This letter is being sent to you because COLA, LLC is proposing a land use project in El Paso County located southeast of the corner of Powers Blvd. and Bradley Rd. This information is being provided prior to a submittal with the El Paso County Planning and Community Development Department. Please direct any questions on the proposal to the referenced contact(s) as listed below. Prior to any public hearing on this proposal a notification of the time and place of the public hearing will be sent to the adjacent property owners by the El Paso County Planning Department. At that time, you will be given the El Paso County contact information, the file number and an opportunity to respond either for, against or expressing no opinion in writing or in person at the public hearing for this proposal.

The request being submitted to El Paso County is seeking approval of an application for a final plat known as the Trails at Aspen Ridge Filing No. 4. The proposed final plat is for 124 single family detached units, utilities and open space. This final plat filing is a continuation of the Trails at Aspen Ridge development project as illustrated on the Trails at Aspen Ridge PUDSP (PUDSP191). The

TRAILS AT ASPEN RIDGE	
 Excellence by Design	
2435 Research Parkway, Suite 300 Colorado Springs, CO 80920 Contact: Nicole Schanel Phone (719) 575-0100 Fax (719) 575-0208	
FILING NO. 4 VICINITY MAP	
JUNE 2021

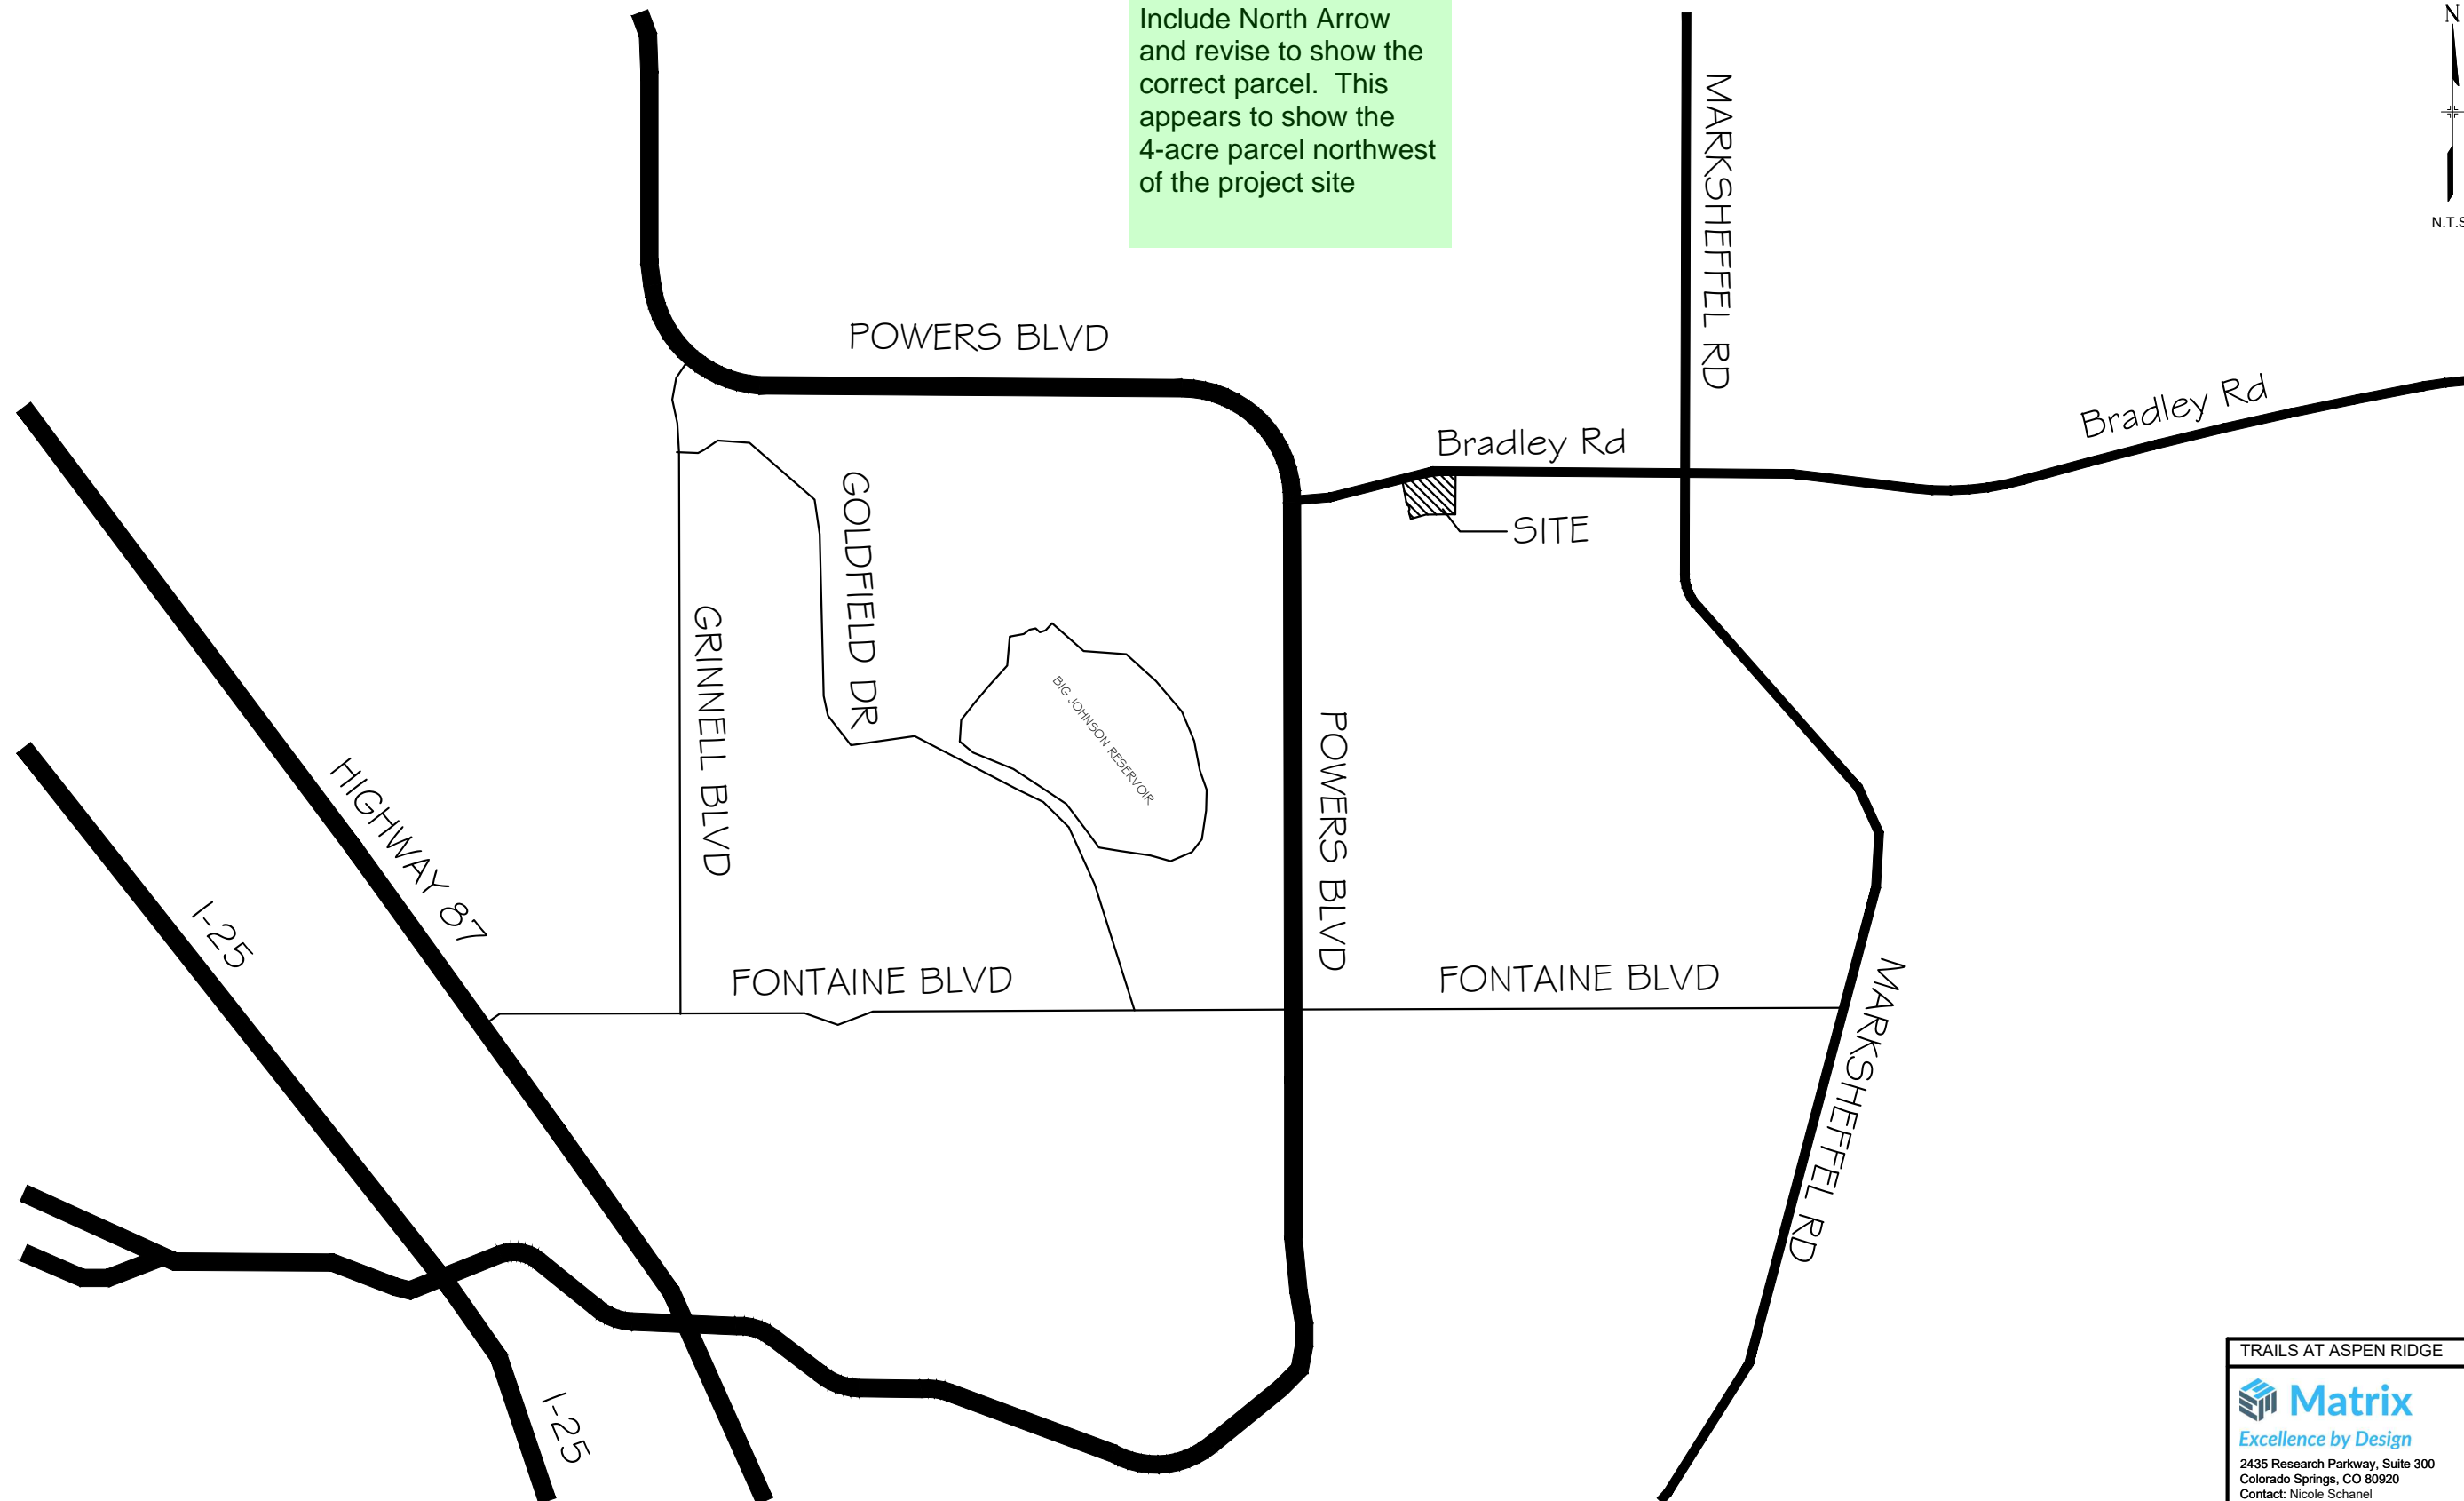
Include North Arrow and revise to show the correct parcel. This appears to show the 4-acre parcel northwest of the project site
